WEST SUSSEX COUNTY COUNCIL CONSULTATION

TO:	Arun District Council FAO: Raymond Cole
FROM:	Stephen Gee WSCC - Highways Authority
DATE:	20 February 2020
LOCATION:	Land to the East of Fontwell Avenue Fontwell
SUBJECT:	WA/48/19/RES Approval for Reserved Matters following outline permission WA/22/15/OUT comprising 400 new homes (incl. affordable), 360sqm of retail space (A1 to A3), 152sqm of community space (D1 to D2 & including retention & refurbishment of 12sqm 'old smithy'), demolition of remaining buildings to Arundel Road along with public open space, LEAP, MUGA, allotments, car & cycle parking, drainage & associated works - This site also lies within the parish of Eastergate. An amendment received.
DATE OF SITE VISIT:	n/a
RECOMMENDATION:	More Information / Modification
S106 CONTRIBUTION TOTAL:	n/a

Rev.	Date	Requirements Description	Drawn	Checked
Client	 dandara Project Land south of Arundel Road, Fontwell, West Sussex.		 aap architecture	
Drawing Title	Planning Layout Sheet 2 of 3			
Scale	1:500 @ A0	Drawn	DGP	Checked AAP
Date	October 2018	File	P1549 Layout	
Dwg No.	P1549.21	Rev.	ZH	PLANNING

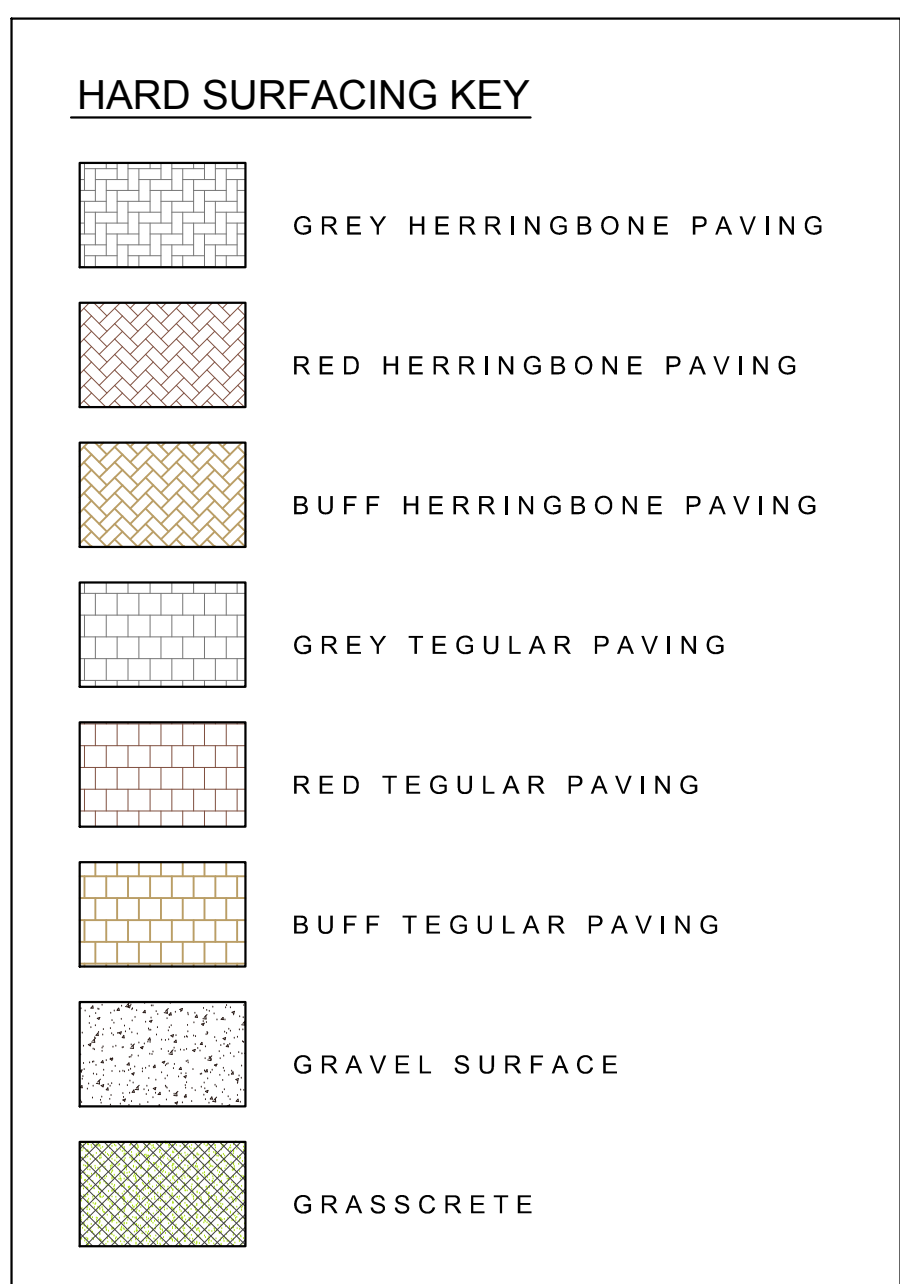
It is noted that the fire tender in the vicinity of plots 363 and 362 would be required to reverse across vehicle parking spaces.

Refuse Vehicle in the vicinity of B20 and B21, C30 and C29 and parking space 33 also appear to over run or be restrictive and as such amendments are required.
